Our Ref: 08092022_4795_RtS_Biodiversity

9 September 2022

RE: John Hunter Hospital Health and Innovation Precinct Project (SSD-9351535 MOD2) – Vegetation Clearing

Scale 1:10000 at A4

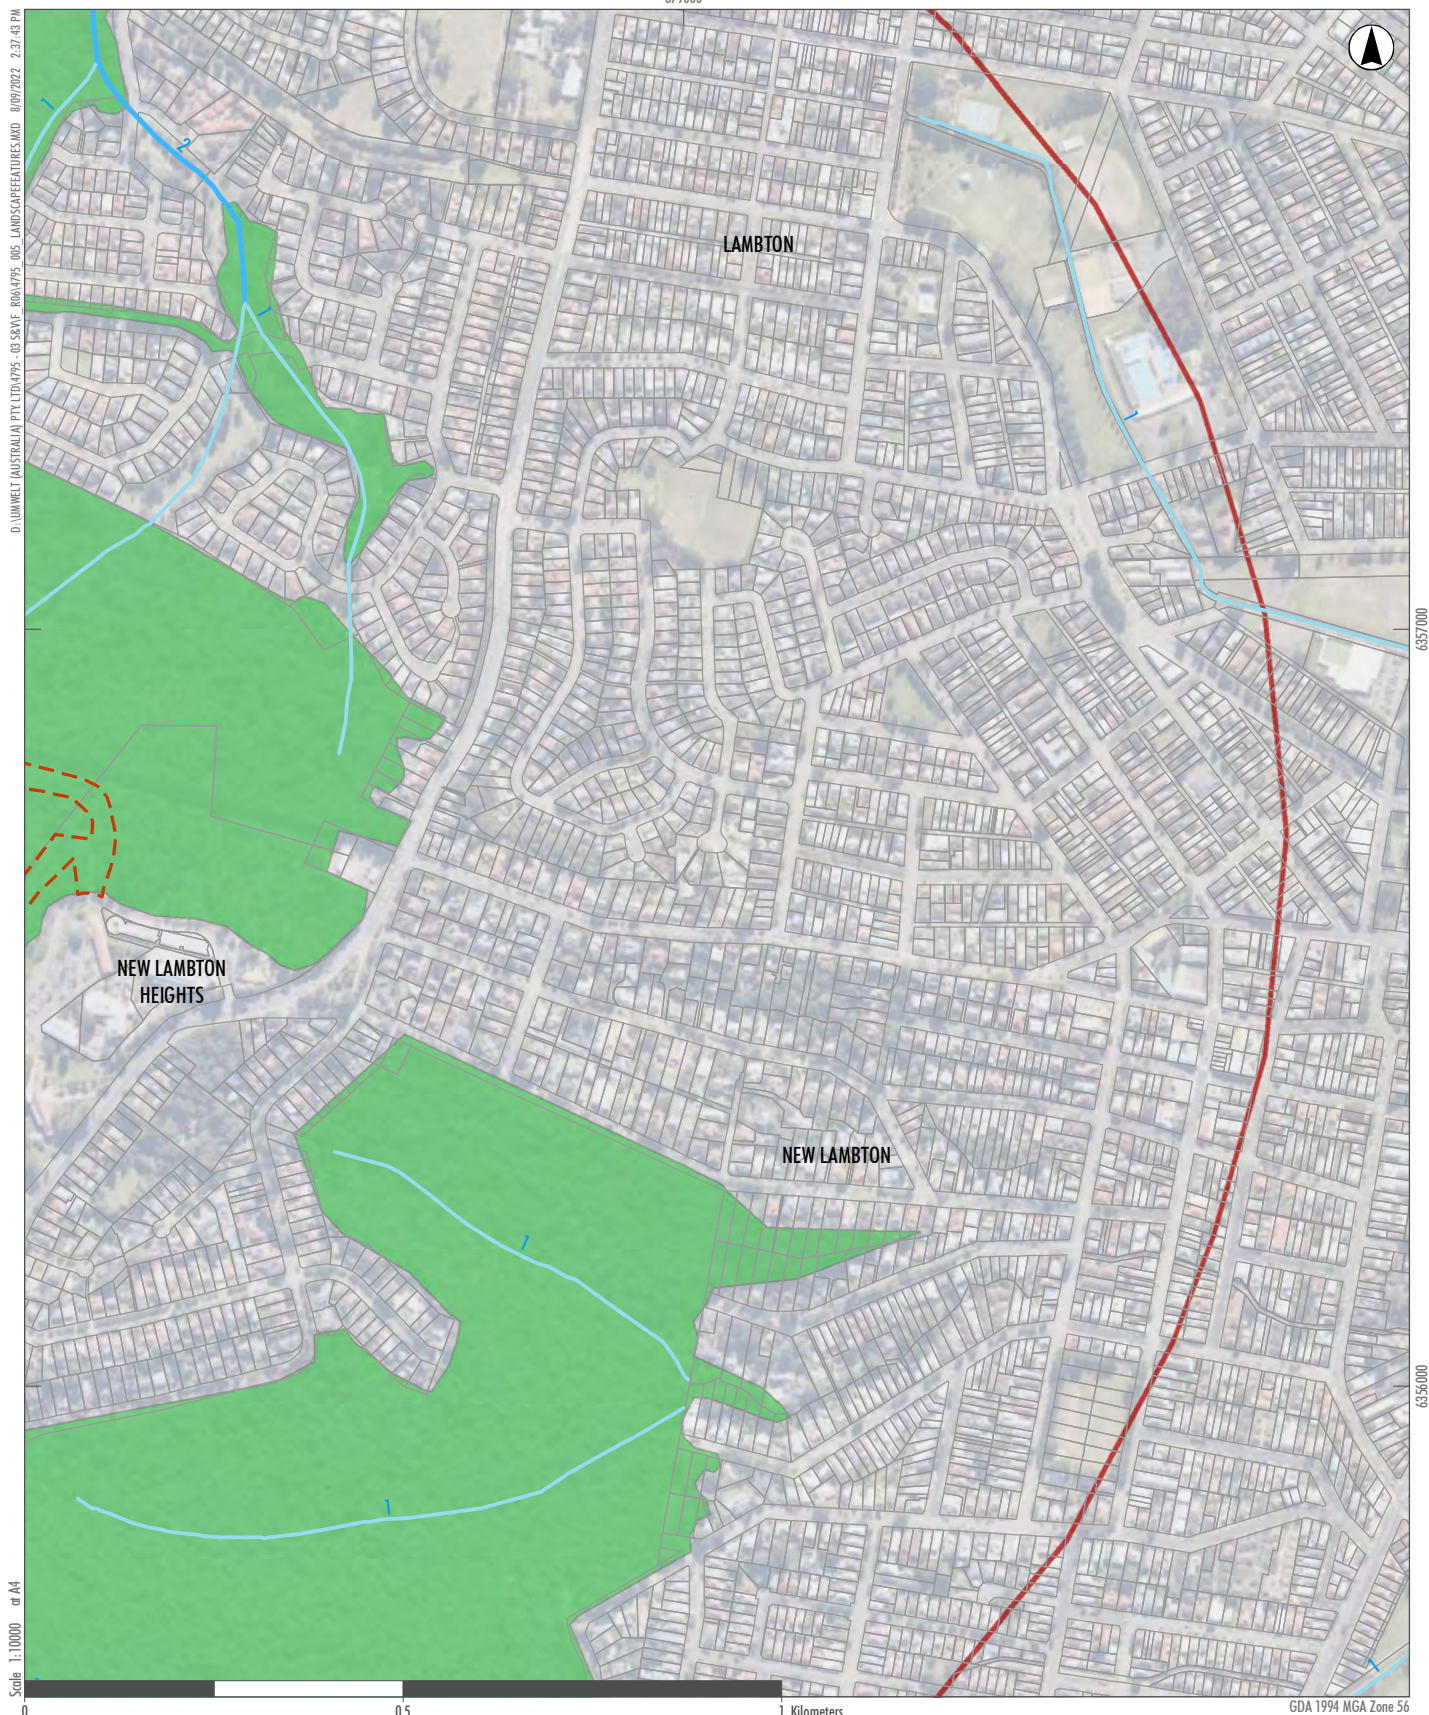
5. BCD recommends that existing maps are revised, or new maps are prepared that show all features required by the BAM.

- 10. BCD recommends a map showing the extent of native vegetation is provided that is at no more than 1:10,000 scale in order to meet requirements of the BAM 2020.**

The entirety of the area shown on all maps is covered by the same IBRA region, IBRA Sub-region and Mitchell Landscape, being the Sydney Basin IBRA region, the Wyong IBRA sub-region, and the Gosford – Cooranbong Coastal Slopes Mitchell Landscapes. It is therefore not possible to show boundaries for these at a relevant scale. Rather than showing the two IBRA layers and Mitchell Landscapes layer on each map and cluttering the figures, each map identifies the IBRA and Mitchell Landscape detail below the legend.

Cadastral has been added to all maps.

Relevant figure has been altered in revised report.

FIGURE 5.1

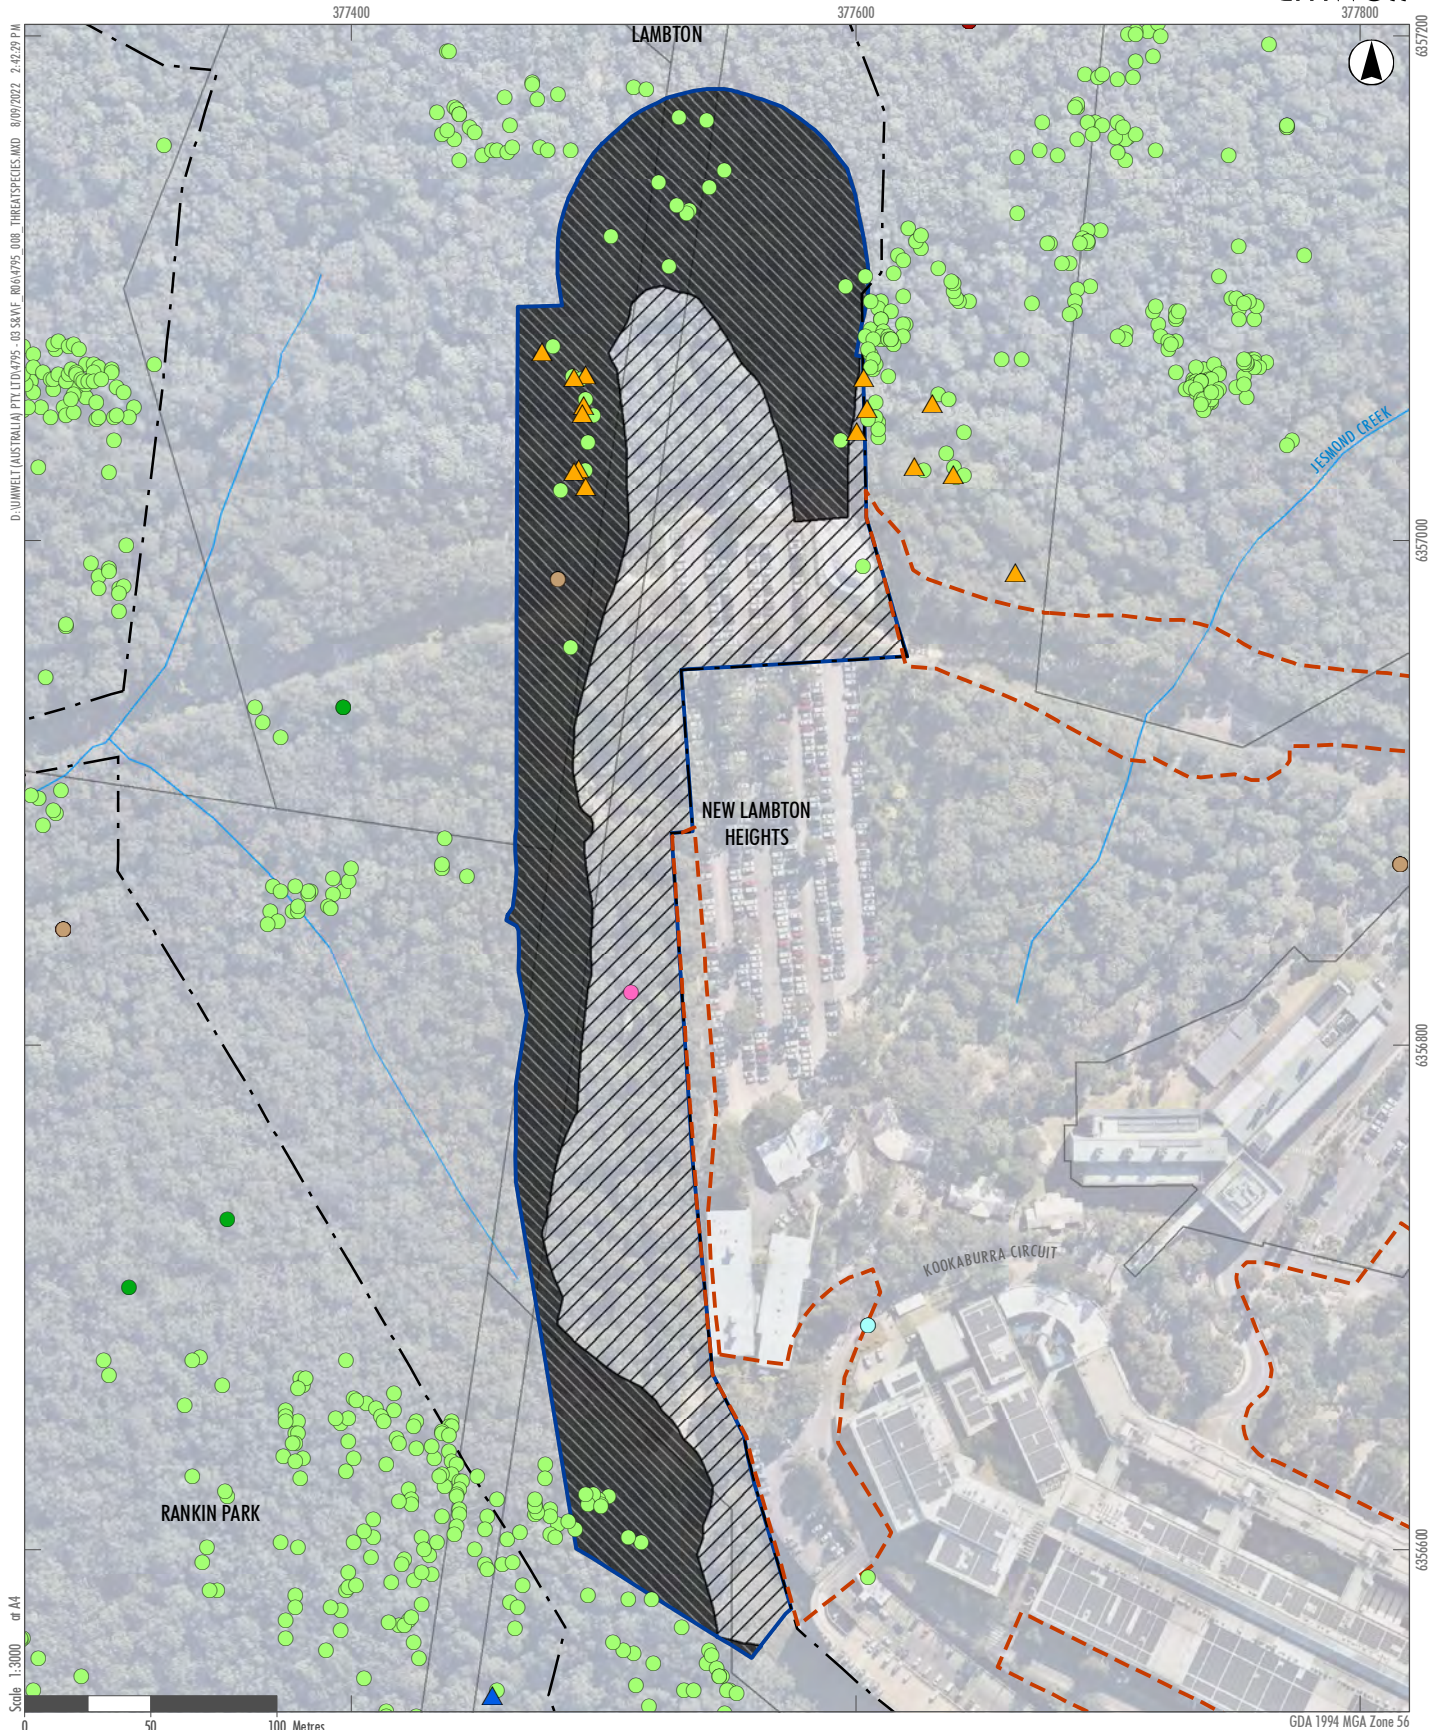
2. **BCD recommends further details are provided of the new local record of *Corybas dowlingii* in relation to the Subject Land and what this means for the assessment.**

require offsets. Figure 5.2. has been updated to show where this species was identified by BCD and verified by Umwelt in June 2022.
